Save the Powerhouse Campaign
savethepowerhouse@gmail.com

Ultimo, 01 October, 2024

**POWERHOUSE ULTIMO REVITALISATION
STATE SIGNIFICANT PROJECT APPLICATION
SSD-67588459
SUBMISSION TO SUBMISSION AND AMENDMENT
REPORT OF 3 September 2024**

Figure 1 Exhibition Spaces

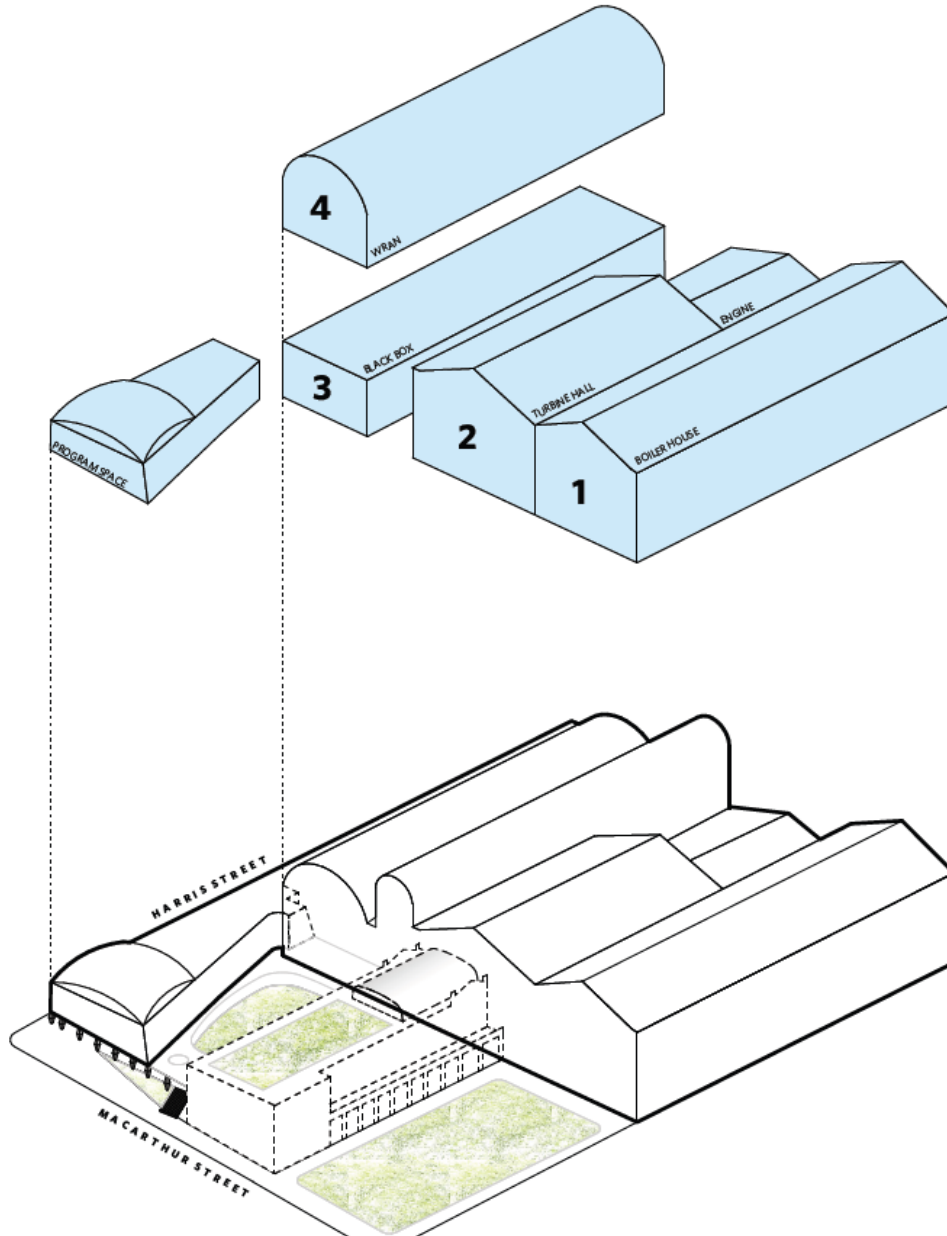
e) The “Revitalisation” application documents detail the proposed exhibition areas as follows -

GF	Space 1	1,900m ²
	Space 2	2,000m ²
	Space 3	900m ²
L2	Space 4	1,200m ²

6,000m ²
Space 3 is not an exhibition space but a theatre		-900m ²

5,100m²

$$5,100 / 21,080 = 24\%$$

Hence, the total exhibition space will be LESS THAN A QUARTER of that existing. This is primarily the result of the systematic demolition of all intermediate levels, galleries and balconies.

The Museum is reduced to 3 large exhibition spaces more **suited to parties and venue hire** than to display the Museum’s **diverse collections**, showing that either the authors of the project deeply misunderstand these collections and/or suggesting a hidden agenda.

Figure 15 Level 1 Demolition

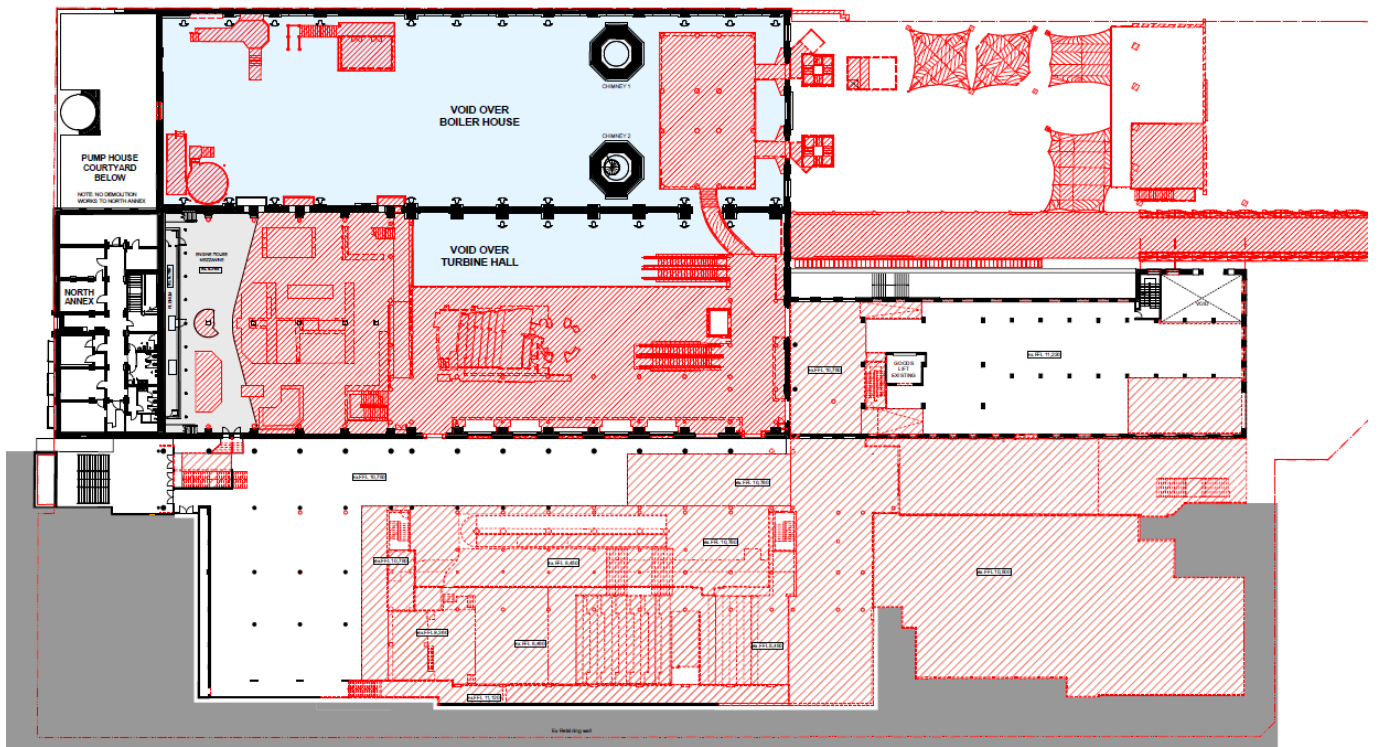
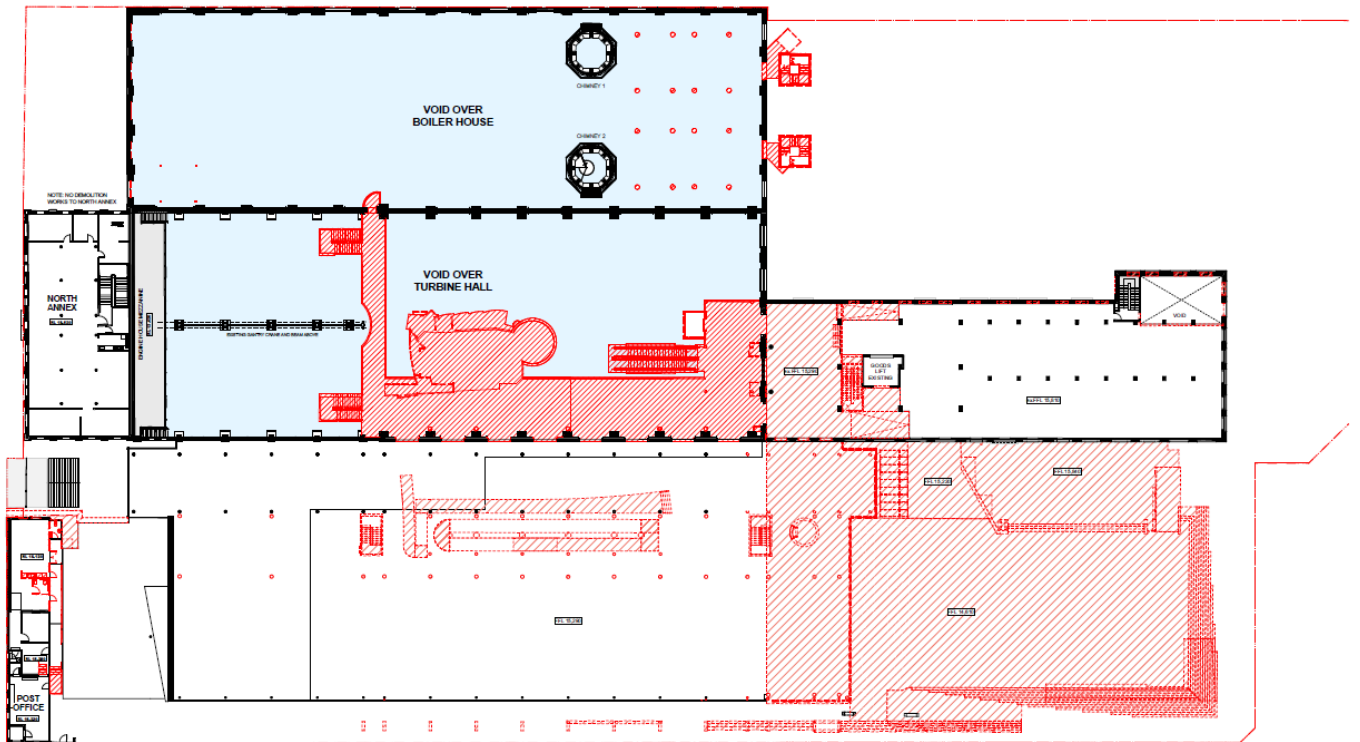
- The demolition of the southern end of the Wran Building and Galleria.
- The conversion of the Galleria into a staircase encased behind brick walls occupying "the (luminous) arched volume...specifically designed to provide a grand setting for the Boulton & Watt engine and Locomotive No1..."

- The removal of several intermediate floors which would reduce the Museum exhibition areas by 75% (21,080m² across 20+ spaces vs 5,100m² across only 3 oversized caverns more suited for contemporary events and commercial use than for the exhibition of the diverse Museum collections).
